# CITY OF ALBUQUERQUE

PLANNING DEPARTMENT – Development Review Services

**RE: Affinity At Albuquerque Senior Housing - McMahon & Finland  
Drainage Plan for Site Development for Building Permit  
Engineer's Stamp Date 4-25-2014 (File: A11D014)**

### Grading Narrative

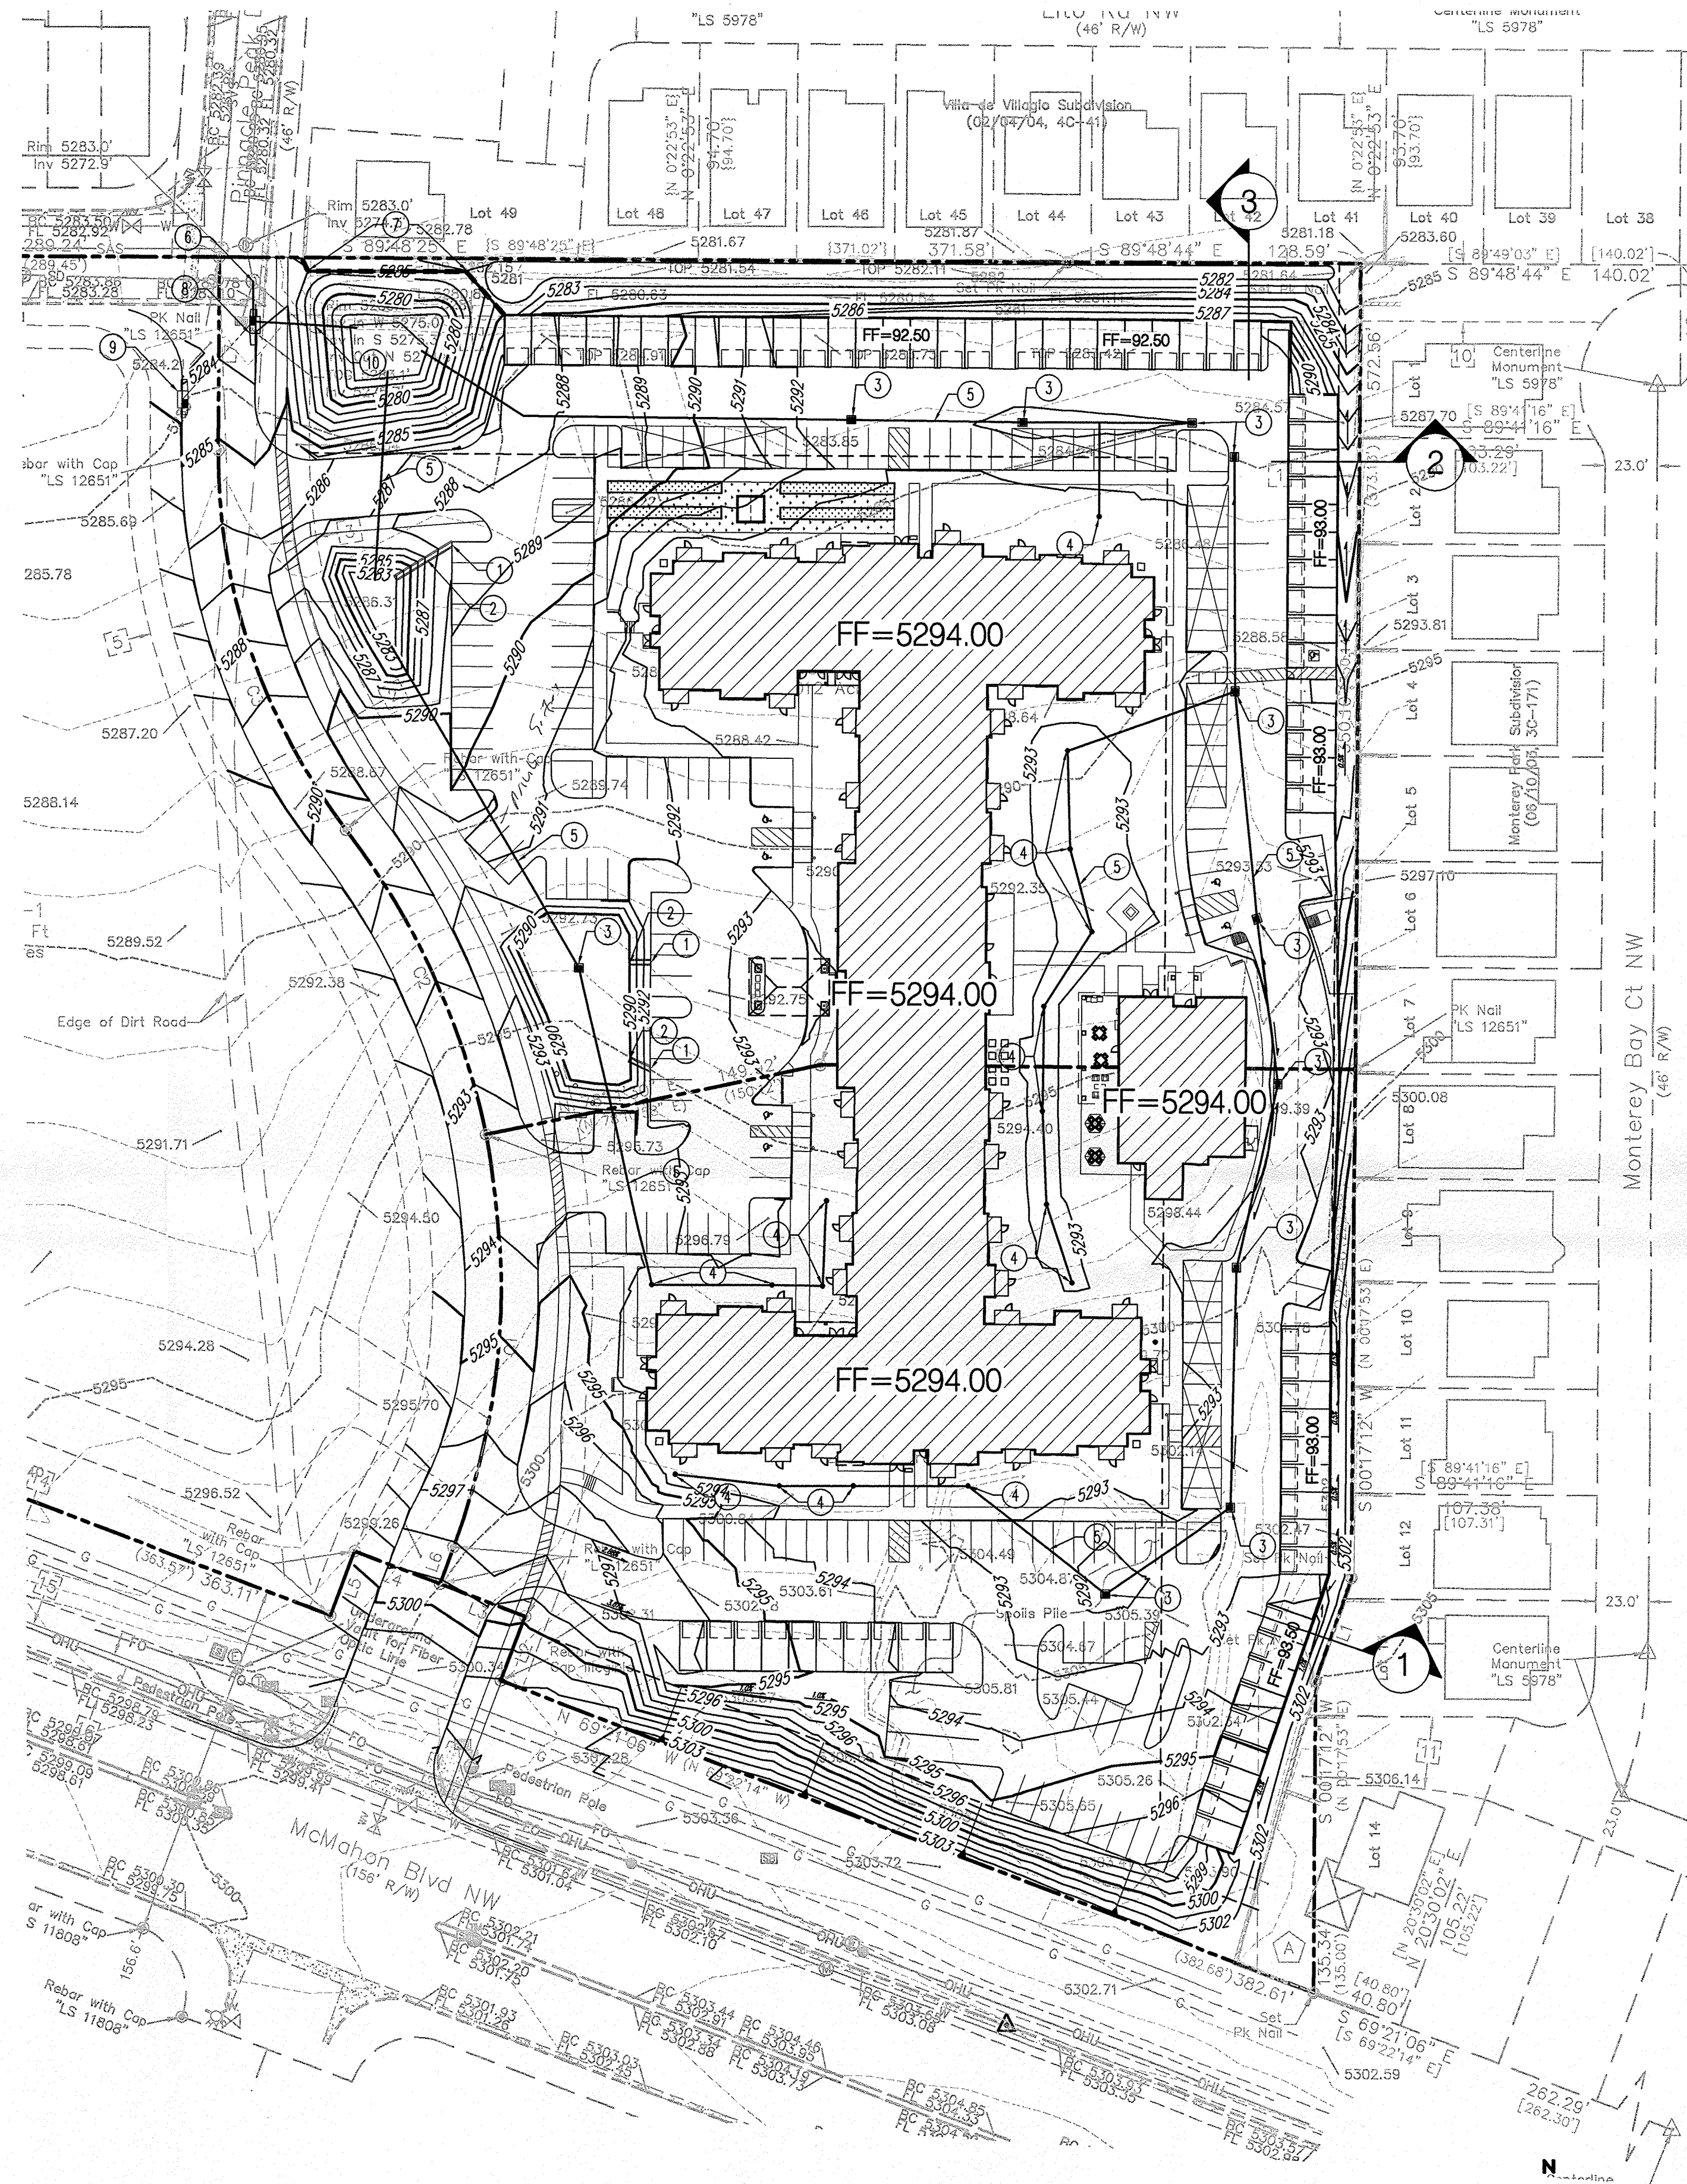
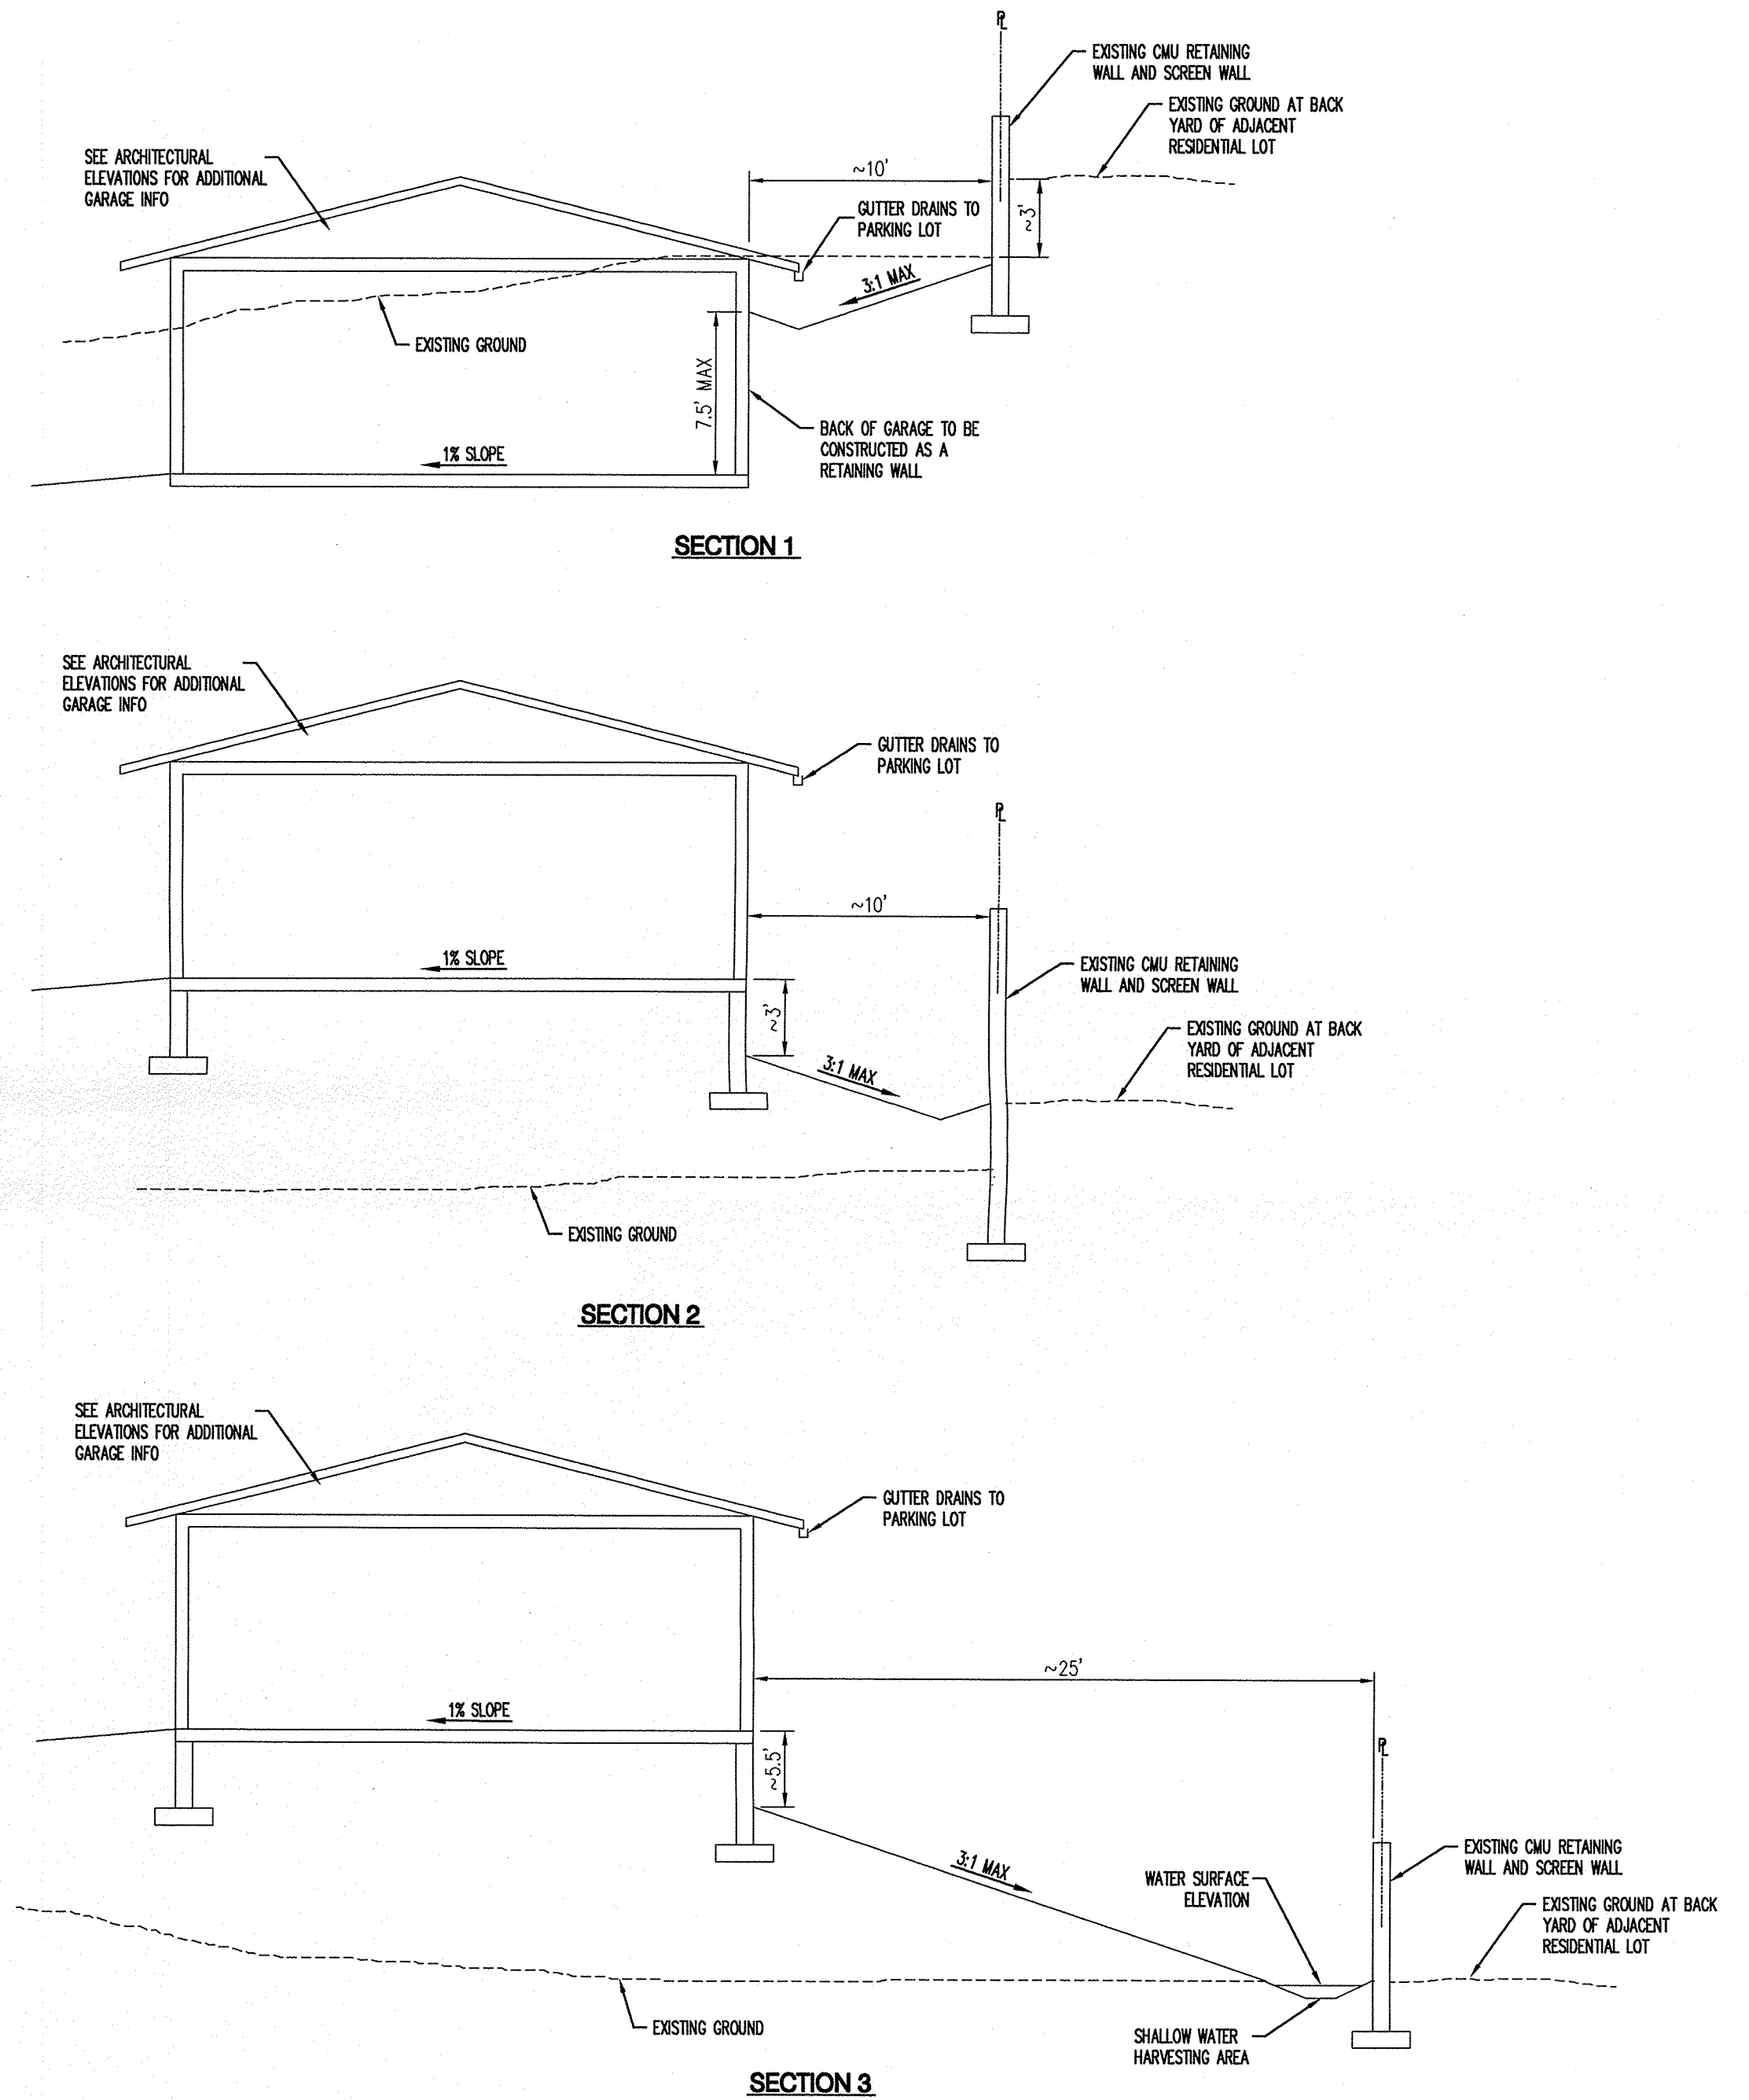
1. Plat indicates 25' pedestrian access easement on north and east boundaries. Water harvesting areas do not accommodate pedestrian access at the given slopes. Is the intent to vacate the easement? Is the intent to vacate the utility easements as well?
2. If the intent is to drain the carport to the parking lot, roof gutters should be shown on all cross-sections.
3. Pond #2 would overflow into Basin 5 as shown. Is the concrete wall intended to separate Pond #2 and Basin #5? Indicate the extents of the concrete retaining wall that is intended to prevent flow to property to the north.
4. Basin #5 along north side of property appears to act as a retention pond. Please provide pond volume calculations and WSEL. How is emergency overflow handled for this pond.

1. Included in this re-submittal is a copy of the vacation action exhibit showing the 25' pedestrian access easements to be vacated (DRB #1000875).
2. Carports will drain to the parking lot. Garages shown in the cross-sections on the grading plan will also drain to the parking lot. Roof gutters have been shown in the revised cross-sections.
3. The wall is intended to separate Pond #2 and Basin #5. The grading plan has been updated to better graphically represent the extent of the wall.
4. Basin #5 contains a shallow water harvesting area along the north portion of the property. Pond volume and water surface elevation calculations have been provided on the drainage management plan. The water harvesting area was sized to fully retain the 100 year 10 day storm. Calculations for the runoff volume are provided on the updated DMP.
